SOUTH HOLLAND DISTRICT COUNCIL

Purpose: To consider Planning Application H16-1131-21

Description: Change of use of existing building from dance/fitness studio (class E) to 2 x 1-bed flats and 5 x 2-bed flats (class C3) including the formation of a pitched roof to existing single-storey projection

Location: 38 SPRING GARDENS SPALDING

Front Elevation (SE)
Scale: 1:100

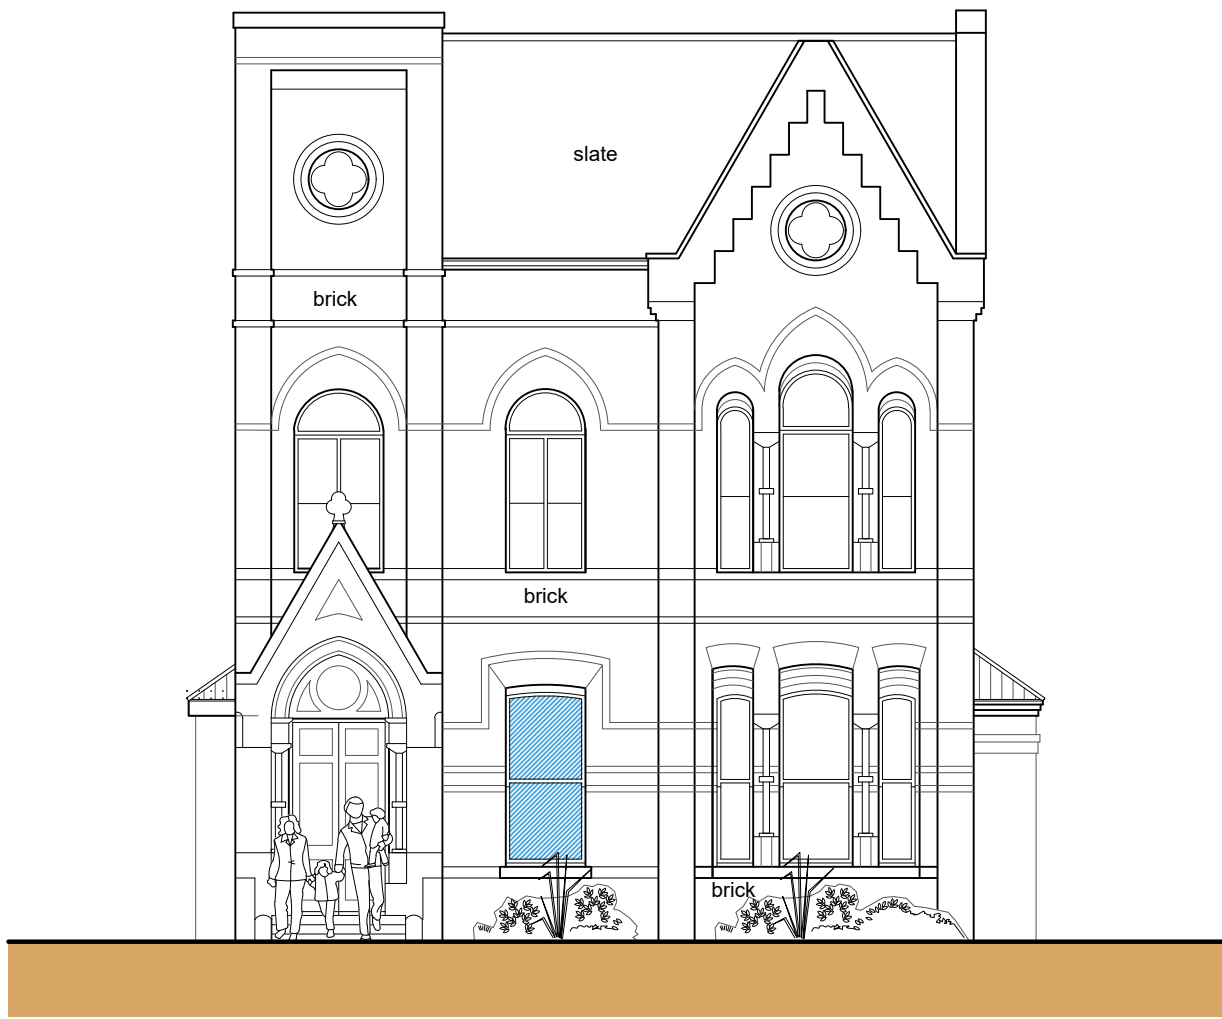
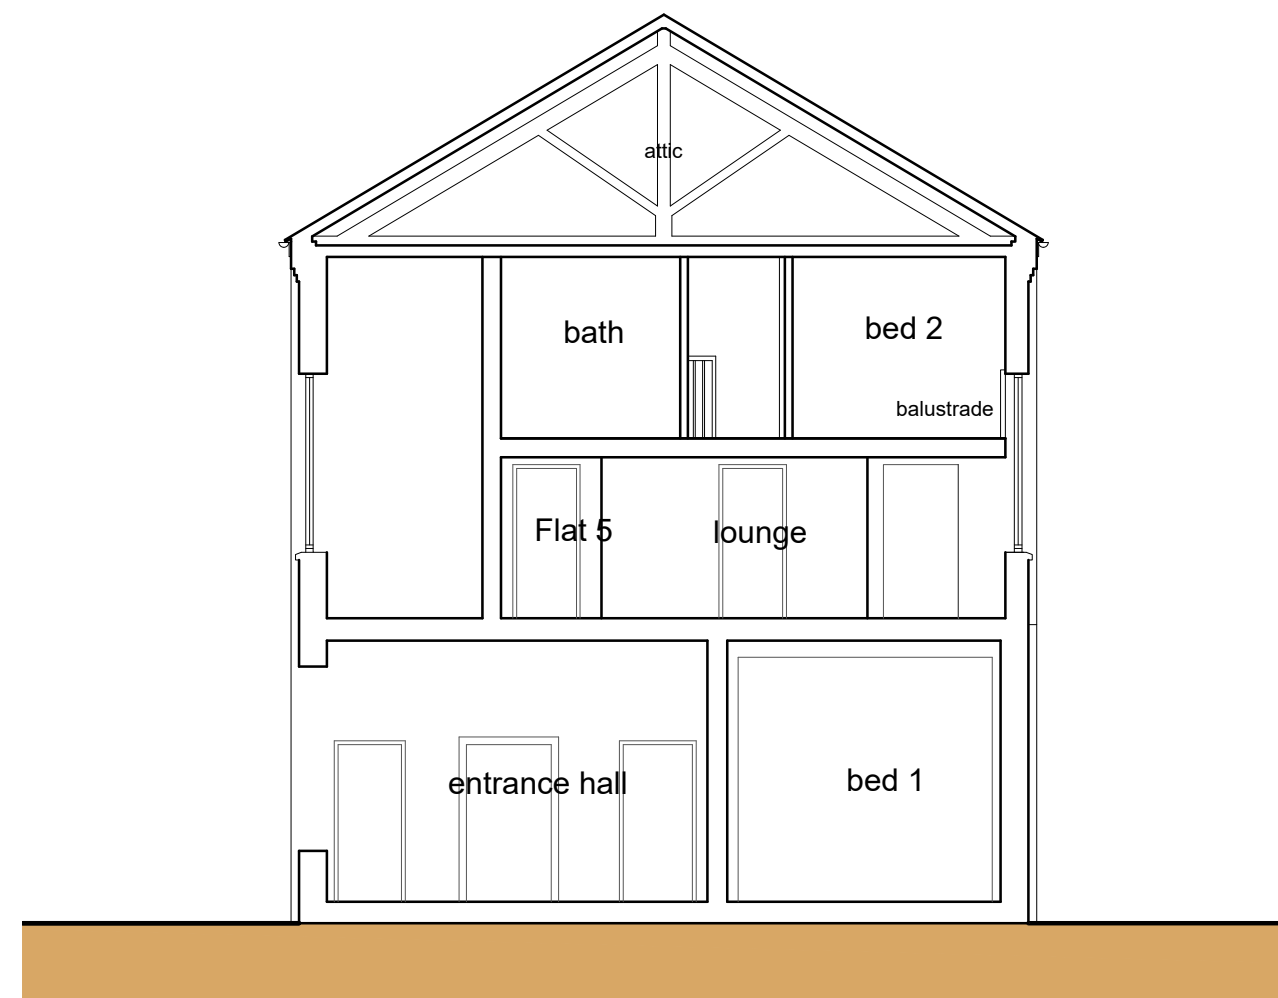
On conservation grounds, the principle behind converting this disused listed property to regular residential use is a sound one. Furthermore, I am satisfied with the proposed external alterations to the property, especially the addition of a slated pitched roof over the extant flat-

FF Plan

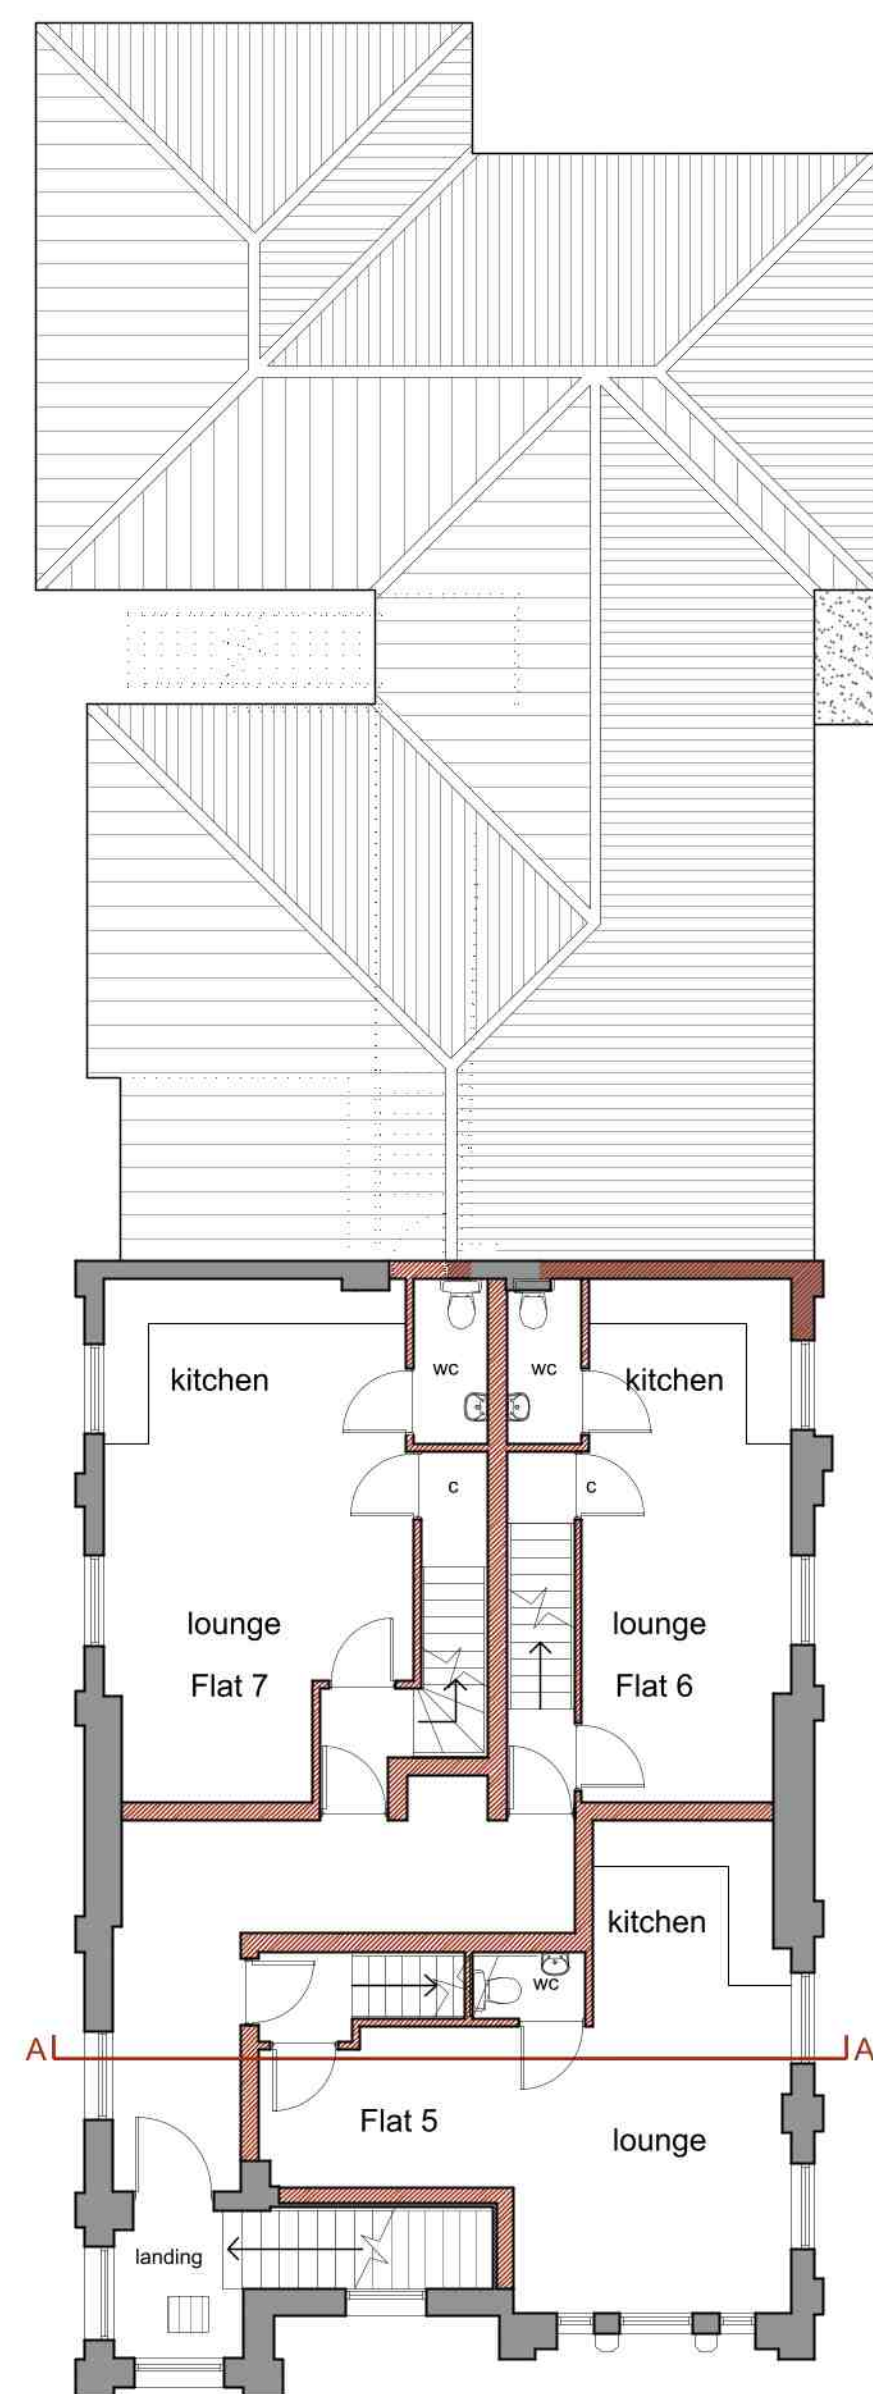
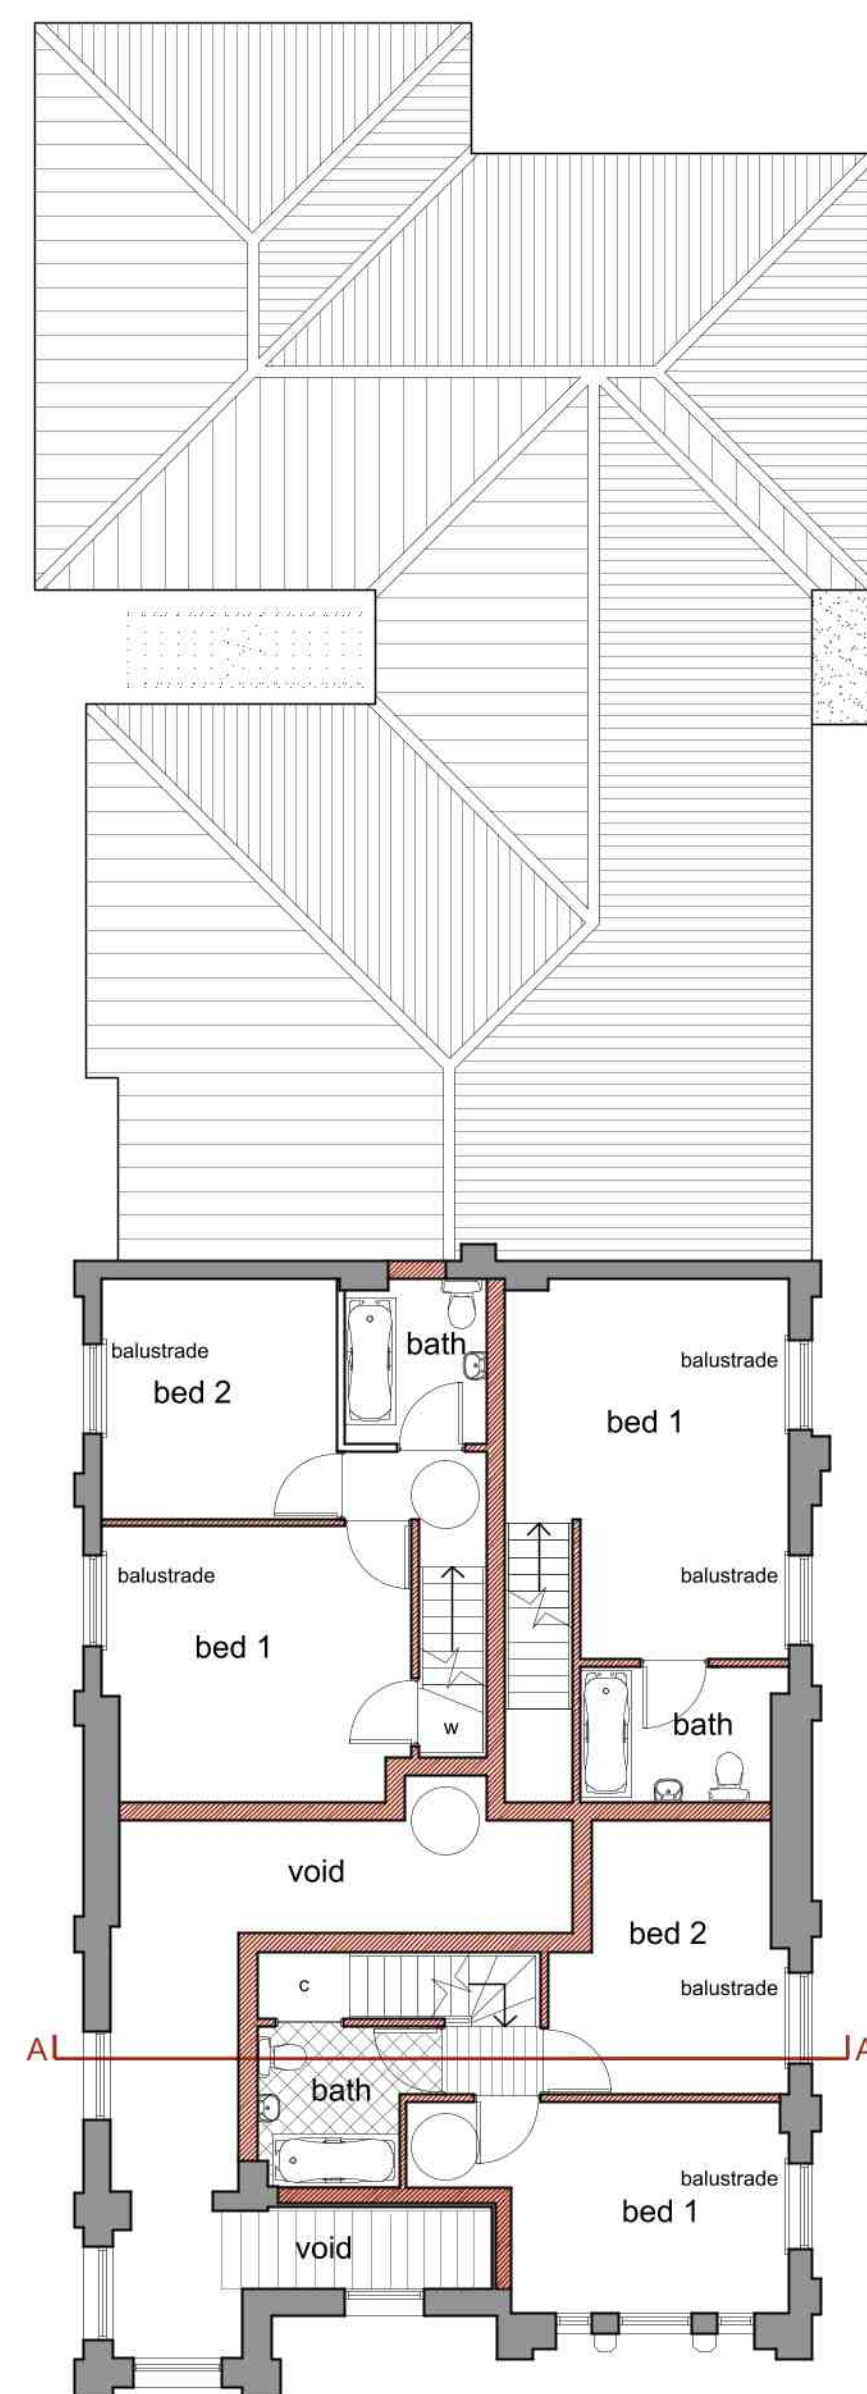
However, having visited the site, I am concerned that the subdivision plan of the 1st-floor dance hall/ballroom risks causing a total loss of significance to this portion of the interior, which is undoubtedly the single most significant source of interior character to this site. The grand, double-height ceiling, mouldings, ceiling roses, and wide-open space with ample access to sources of natural light would be lost with the proposed extensive subdivision and the addition of a full-size mezzanine floor. I would recommend that the applicant should be required to present an alternative floor plan proposal that substantially cuts down the subdivision on the 1st-floor level and that is more respectful of the internal character of the property.

As an absolute minimum, I would expect that mezzanine floors should be recessed from the windows in order to preserve the character and contribution of the full-height windows, and subdivision should be planned such that it does not affect the character features of the interior.

Following discussions with the applicant's representatives and subsequent revisions of the proposed floor plan, I am now satisfied that the proposed layout of the former ball room area, to be converted to apartments is satisfactory in that it preserves key architectural features and is now much more open plan, preserving the wider, open character of the space. Therefore, I have no further objections or comments, and the case officer should continue to consider the application in accordance with all relevant policies and guidance.
